3996 INNES ROAD

Application for Site Plan Control Approval – Cover Letter -Response to Initial Urban Design Review (UDRP) Comments, file No: D07-12-21-0209.

January, 09, 2023

SITE PLAN

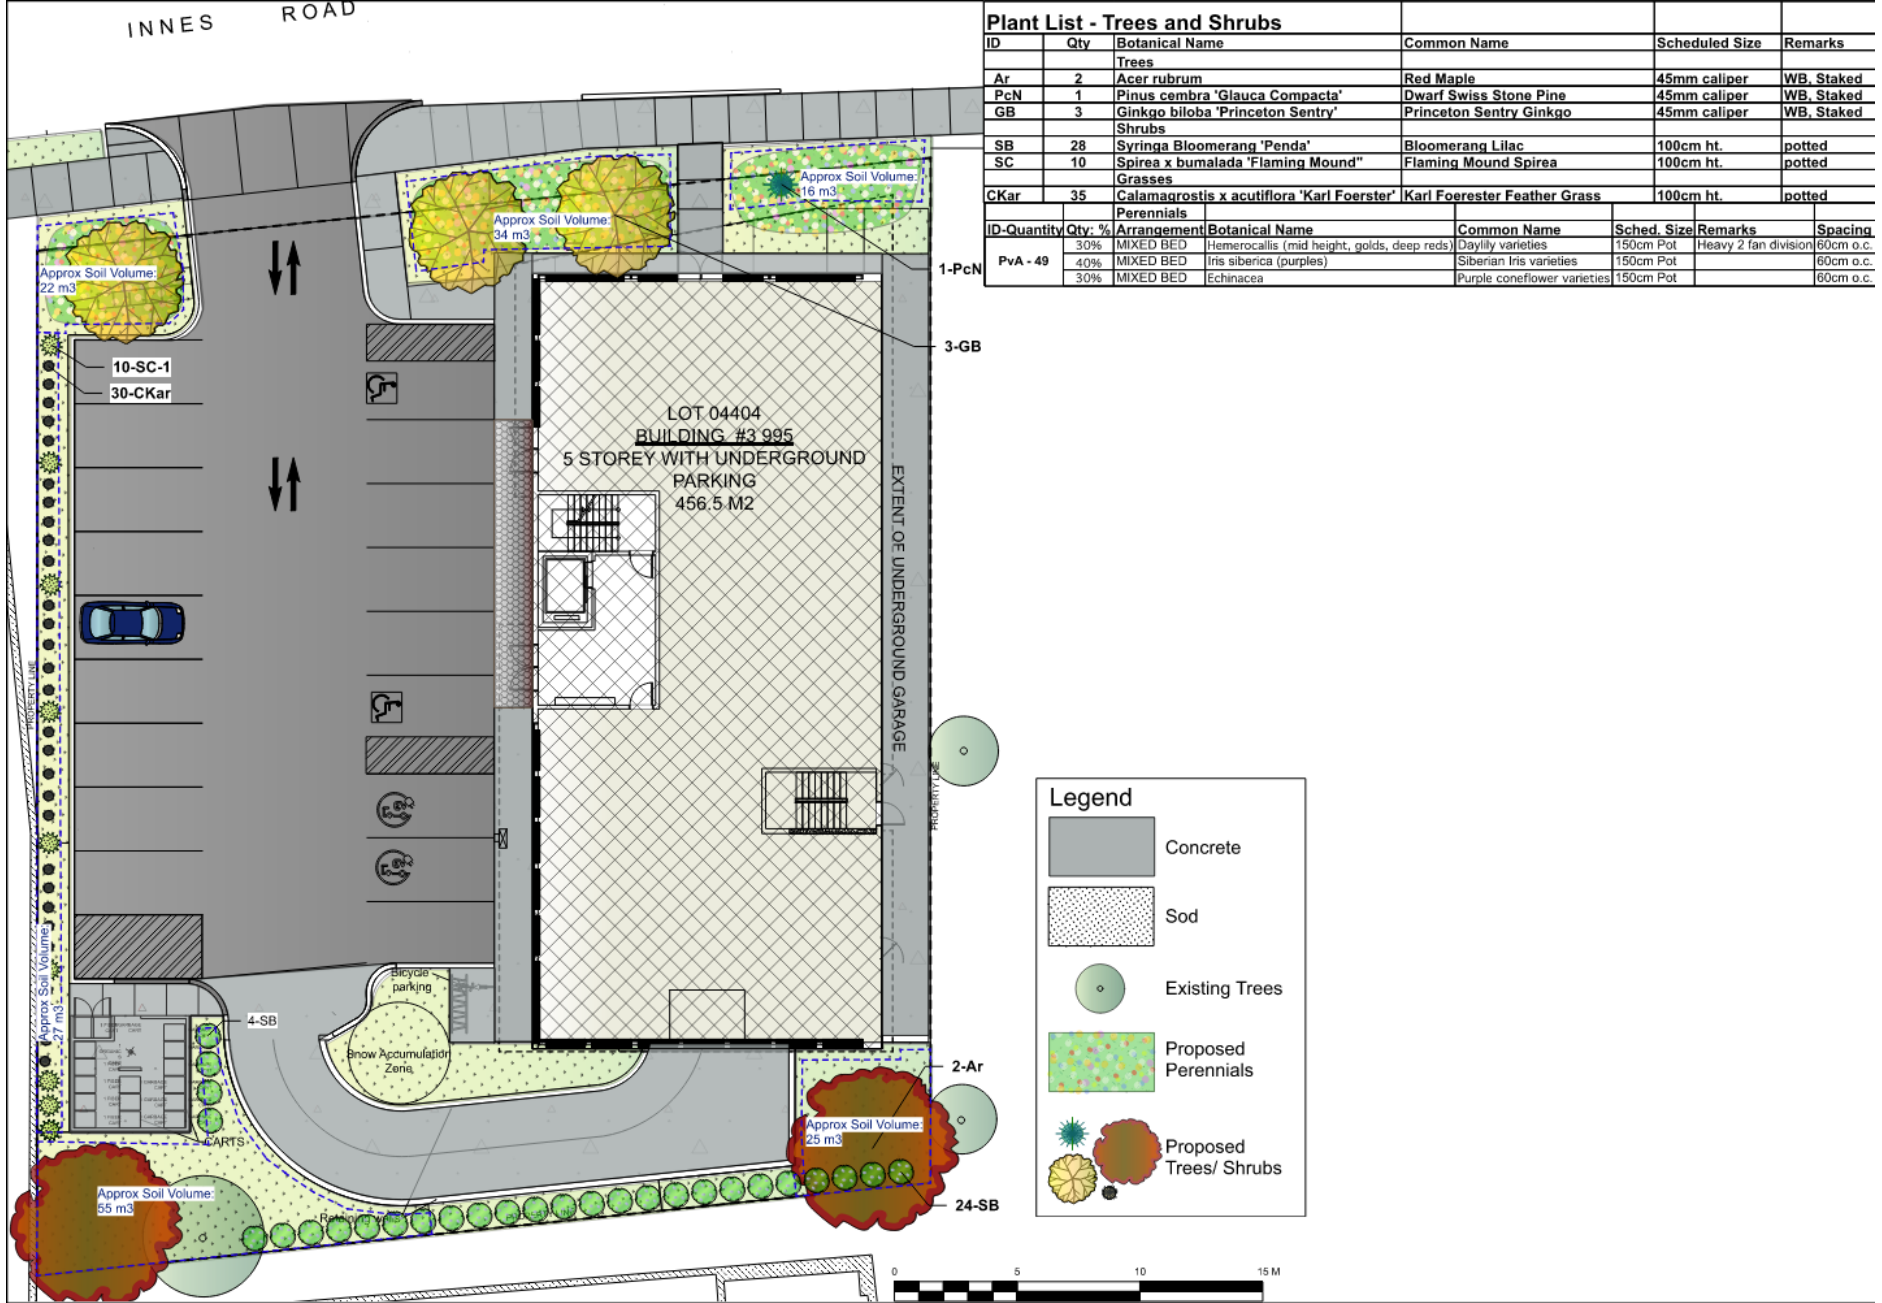
- “There is an opportunity to widen the sidewalk on Innes Road and provide a more comfortable pedestrian environment. The proponent should also consider the landscape treatment typical of a broader street cross section, with more significant setbacks, and introduce more planting and landscaping.”

Although city has not yet design the proposed widening, the design team and the landscape architect work together to provide significant landscaping in the front of the building. Refer to the revised landscape plan. The maximum setback that will not affect the underground parking and the commercial area was provided beside the required setback for the future widening road. 4.1m for the north-east side and 3.4m for the north-west side corner was provided as a landscaped area in front of the building. (See Figure: 2)

**SOUTH WEST ELEVATION**

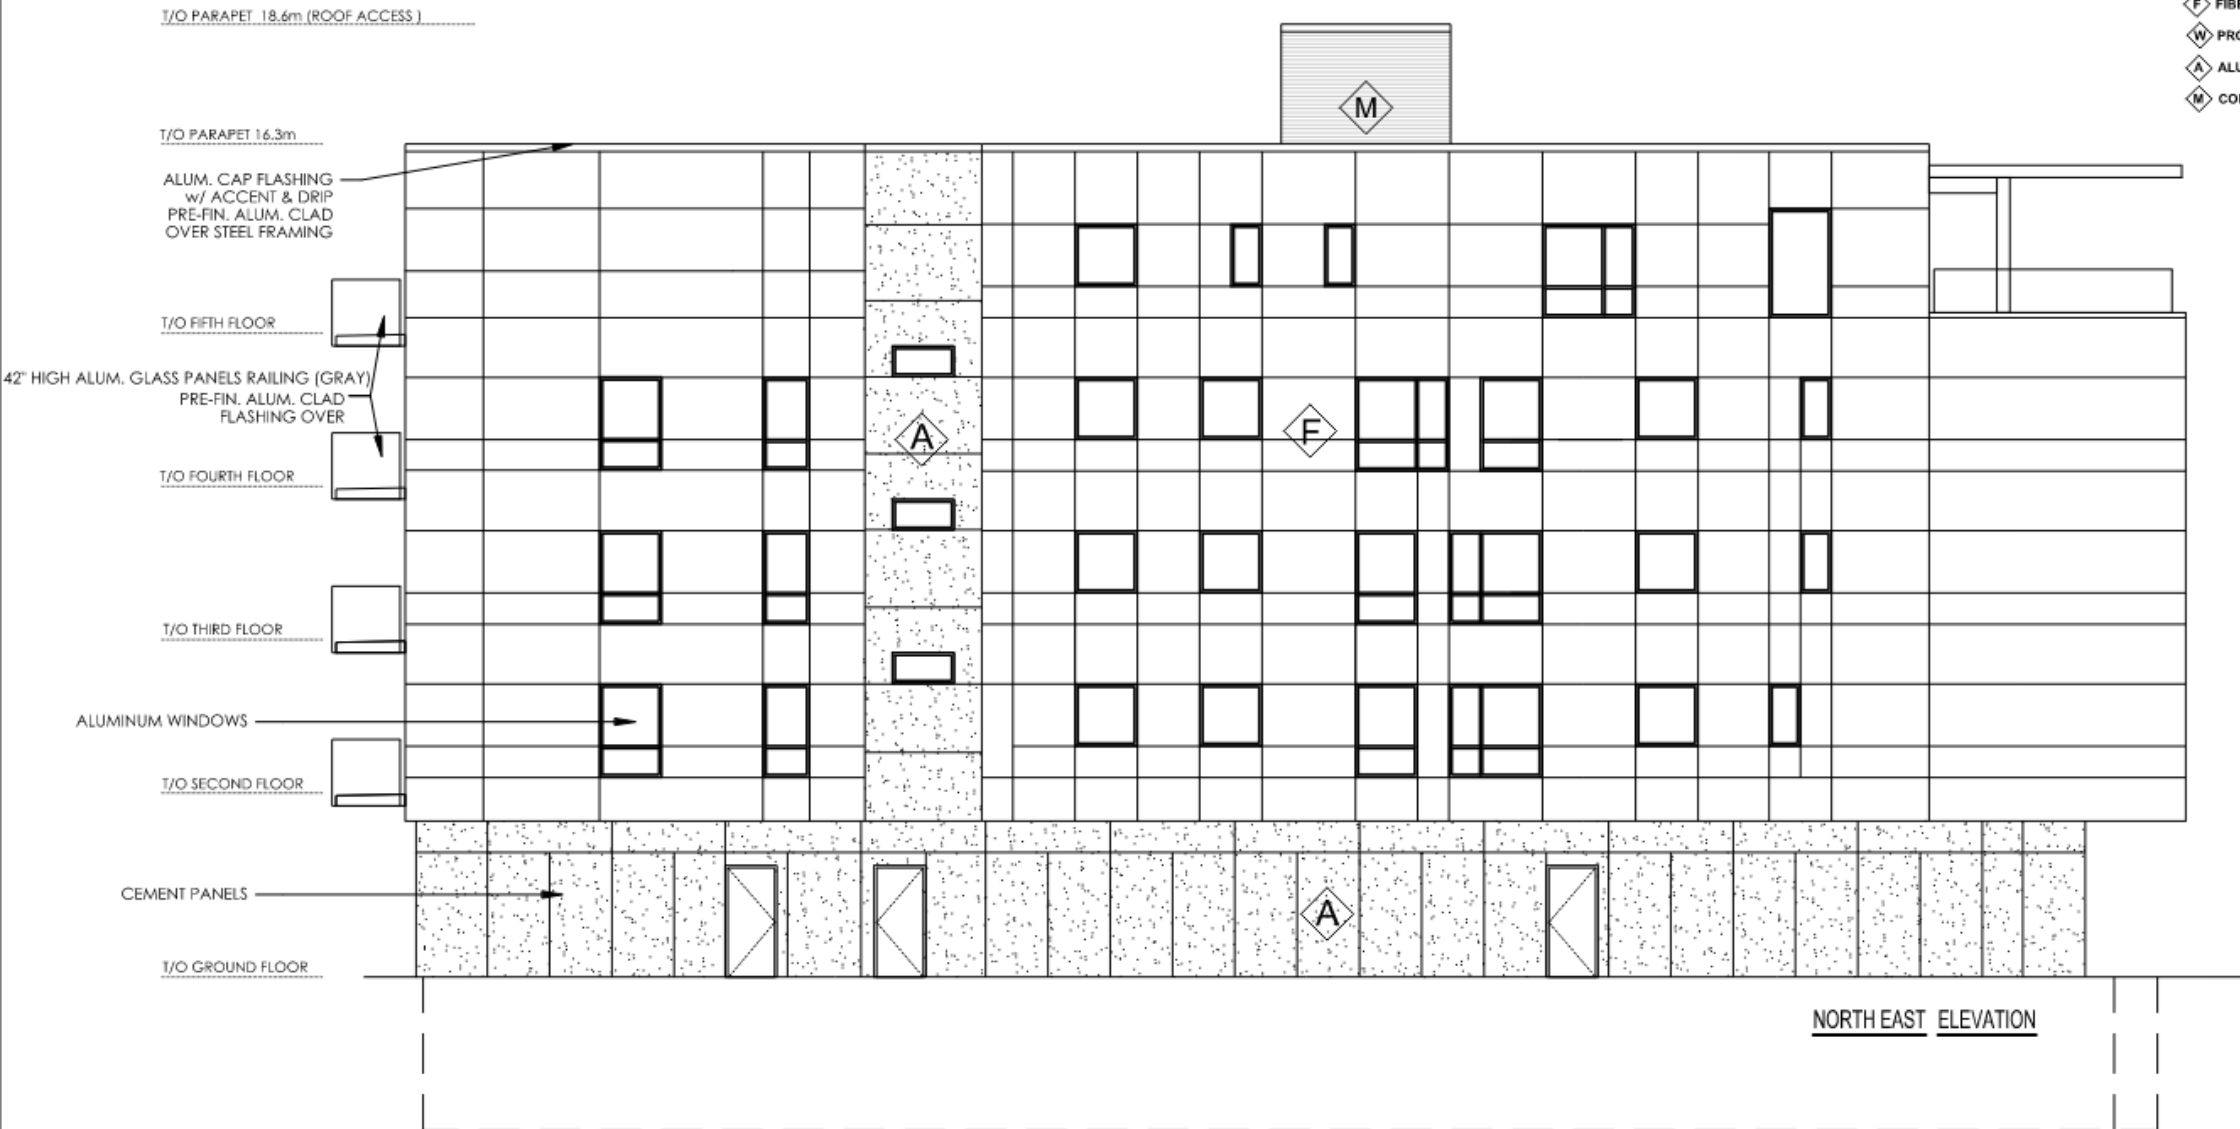
- *“The Panel believes the dark base treatment feels unwelcome and gives the impression of a squat ground floor. The proponent should consider introducing different materials to break up the glass façade.”*

The building base consists of the commercial facades and the residential main entrance /hallway. The dark effect is related to the 3d rendering issue and 3d view was revised to reflect the real effect of the transparent curtain wall. The 2 feet dark fibrocement panels above the curtain wall are intentional to give the sense of floating to the above residential white mass. (See Figure: 3) and (Annex A)

# Site Plan

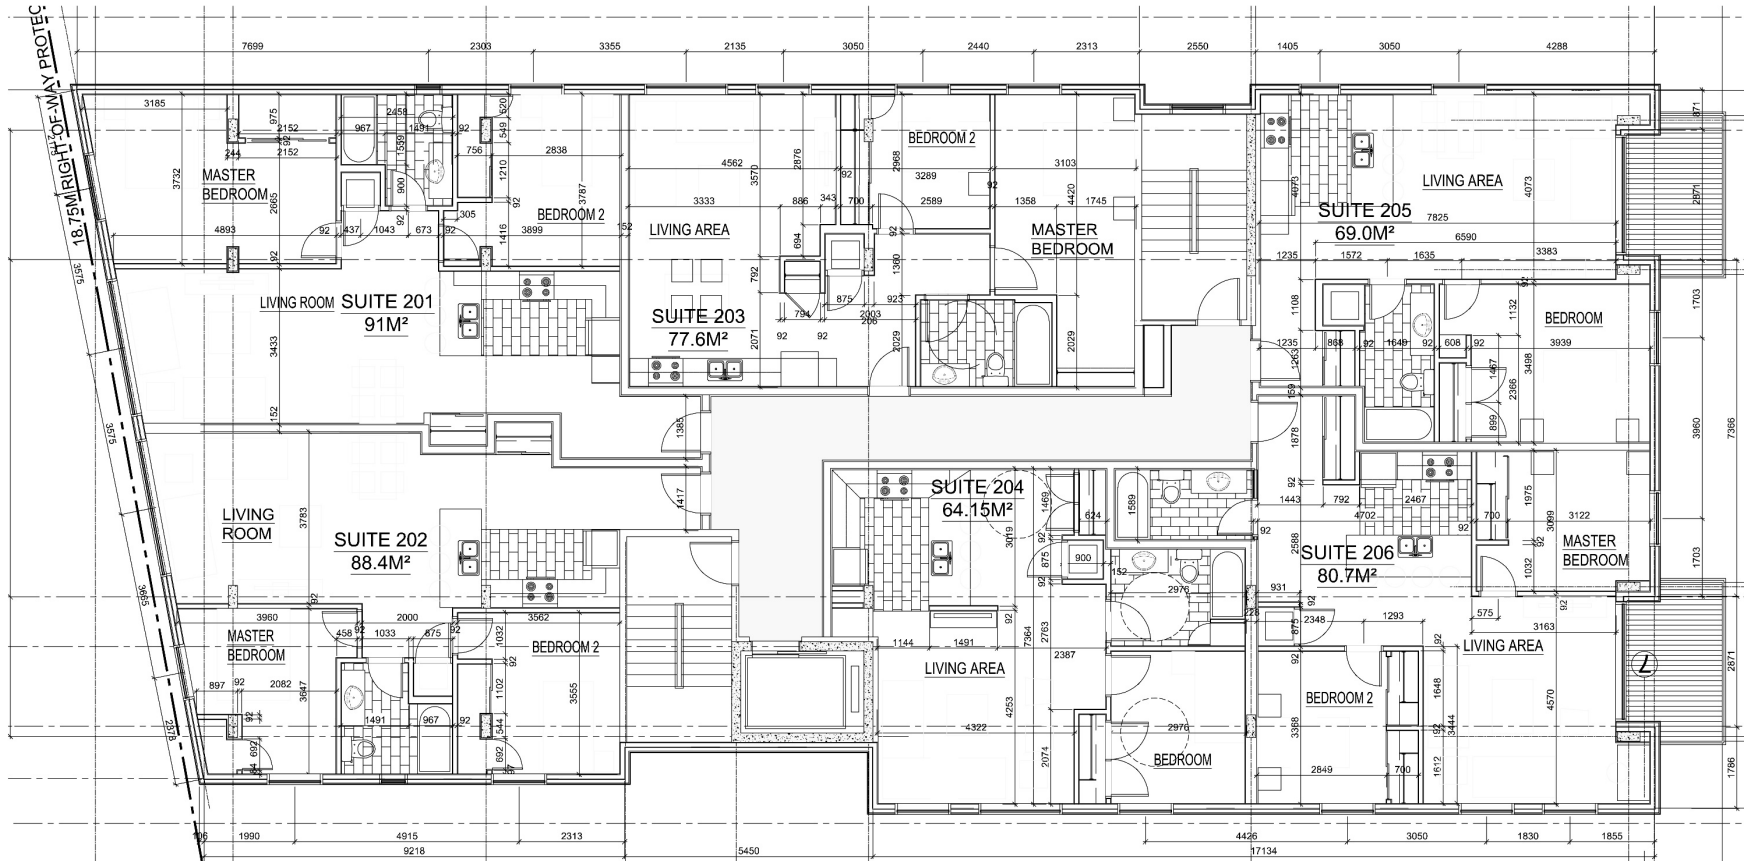
- *"The overall look and feel of the building are appreciated, but the building's proximity to the lot line is a concern, given that it will affect the development potential of the adjacent site. Should the massing remain the same, the Panel recommends shifting the building to maintain a minimum of 5.5-metre separation distance to the lot line."*

The zoning mechanisms permit no minimum setback to the East property line. The Proposed design allows a 2m wide landscaped separation area between the property line and the proposed building face. Increasing the setback to 5.5m is not a vital option for the development of this tight site. Several reasons are prevent the increase of distance setback to the East side as below: (See Figure: 1)

- Increasing the side yard setback distance to 5.5m will affect the parking area to the west side. One raw of parking spots consist of 10 parking spaces;
- Increased building cost significantly due to underground parking increased area to compensate the lost of barking spots above grade.
- If underground car parking spots proposed are more than 20 stalls (30 stalls required in this scenario), the access ramp should be 6.7m wide and there is no space to have such wide ramp. Commercial are should in this case revised to allow such space for the ramp. The commercial are will be affected negatively to accommodate the required area for the pharmacy and the clinic.
